To: Mike Giampa 110 Laurier Avenue West, 4th Floor Ottawa, ON K1P 1J1 File: 6420 Ottawa Street – Mattamy Richmond Village	From: Lauren O'Grady, P.Eng. 400 – 1331 Clyde Avenue Ottawa, ON K2C 3G4 Date: September 9, 2019
--	---

Reference: 163600873 – Mattamy Richmond Village

In June 2019 Stantec Consulting Ltd. (Stantec) prepared the *Richmond Subdivision Transportation Brief Update* on behalf of Mattamy Homes (Mattamy) for a proposed residential development located in Richmond Village. In August 2019 Stantec received comments from the City of Ottawa.

Table 1 below includes the comments from the City of Ottawa along with the accompanying responses by Stantec.

Figure 9 - Site Traffic – AM Peak Hour

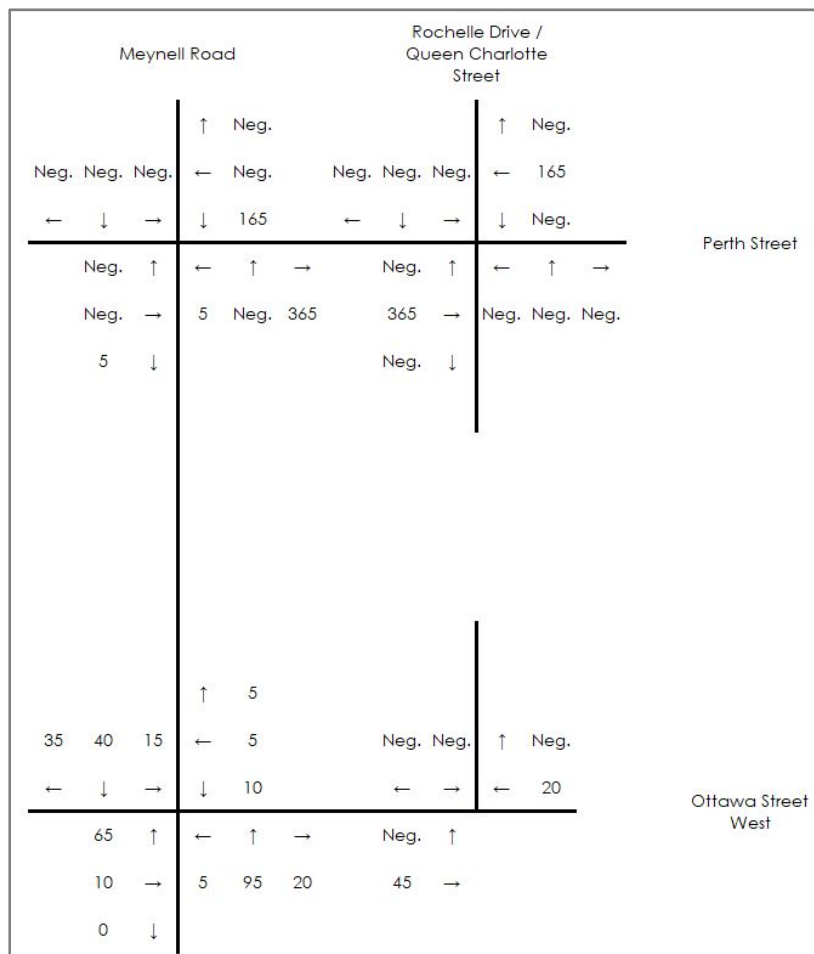
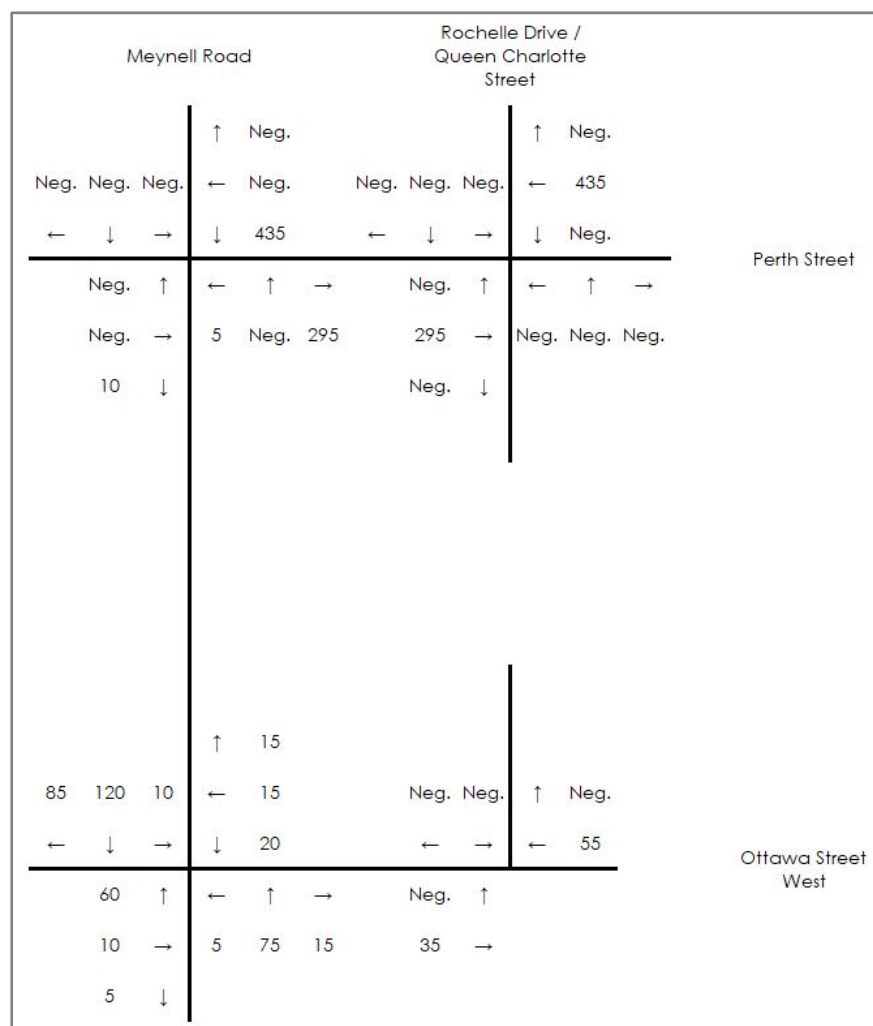
2	<p>In section 3.3.2 Vehicle Site Trips- it is unlikely that the proposed subdivision plan would have an "in" value of 222 in the AM and the "out" value at 306 trips. With the number of proposed developments both the percentage of vehicles and the vehicle volume coming out of the community would be higher. Please revise these figures to show a more realistic volume increase and split.</p> <p>Additionally, the vehicle-trips shown on Table 4 do not correspond to Figures 9 and 10. Correct these.</p>	<p>This statement is incorrect. Table 4 in Section 3.3.2 indicates that during the AM peak hour, there are 222 vph entering and 494 vph exiting.</p> <p>The volumes in Figures 9 and 10 were rounded to the nearest 5 vph, therefore, they are slightly more conservative than what is outlined in Table 4. The analysis was based on the rounded volumes; therefore, no changes are required.</p>
Traffic Signal Design

Figure 18 - Proposed Transit Route and Transit Stops

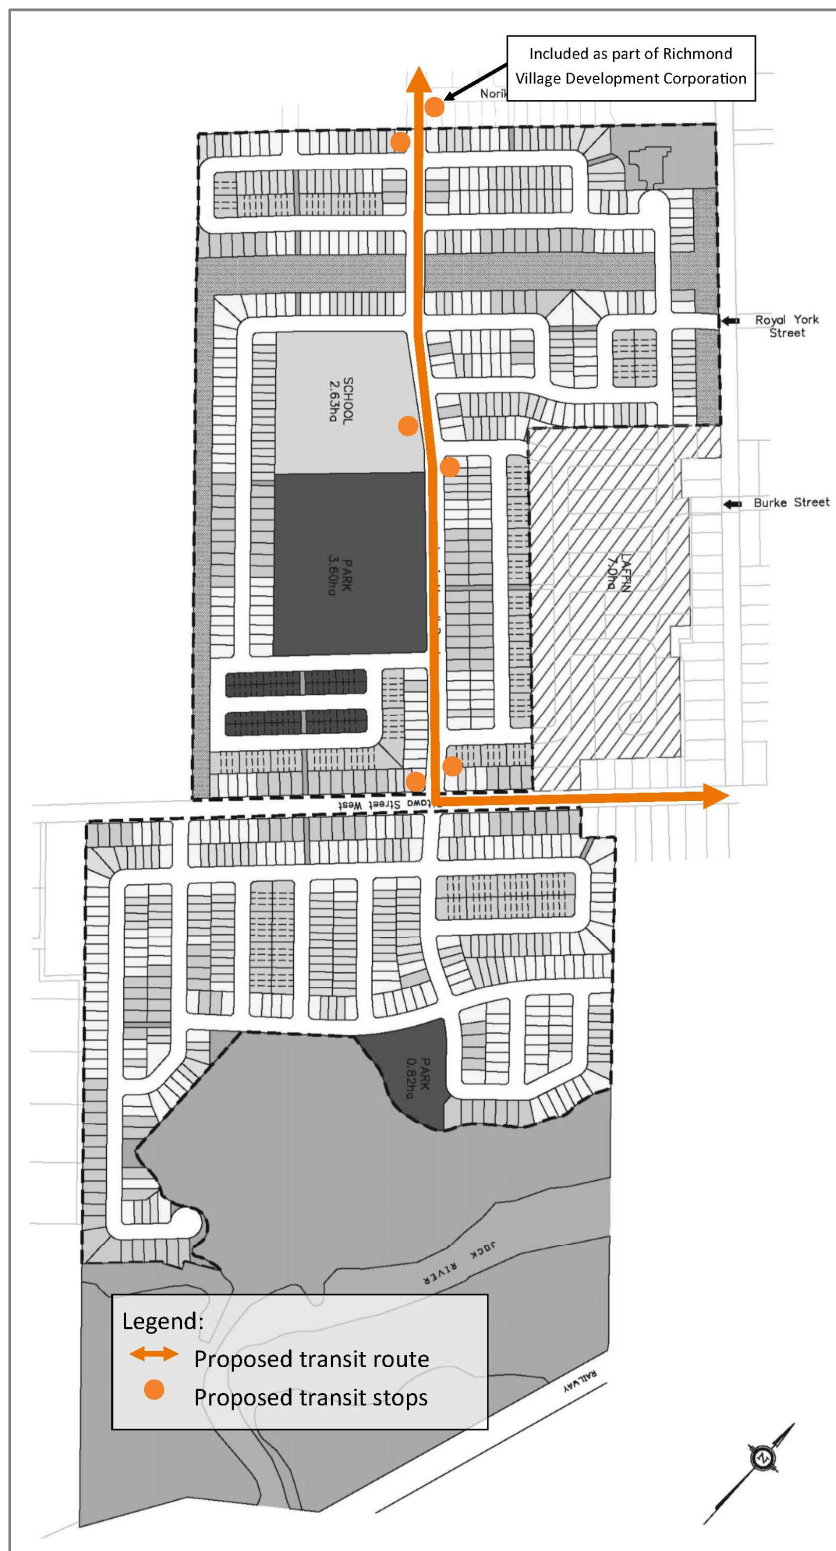
Transit Services		
13	<p>The proposed transit route as shown in Figure 17 is appropriate – it is anticipated that transit service may be provided along Meynell Road and Ottawa Street.</p> <ul style="list-style-type: none">As noted in Section 7.0 (Draft Plan Review), curb radii at the intersection of Meynell and Ottawa should accommodate transit vehicle turning movements.The proposed roundabout at Perth and Meynell should also be designed to accommodate transit vehicle turning movements in all directions.	Noted.

14	<p>The proposed bus stop location on the east side of Meynell opposite the school conflicts with the front-facing homes. In this configuration, it will not be possible to provide adequate bus stop infrastructure.</p> <ul style="list-style-type: none">Consider rotating the lots highlighted below to face the side streets, leaving a side-lot along Meynell which can accommodate a bus stop and/or other utilities. 	<p>These lots have been reoriented to accommodate the required bus stop infrastructure. The revised Draft Plan can be seen in Attachment 1.</p>
----	---	--
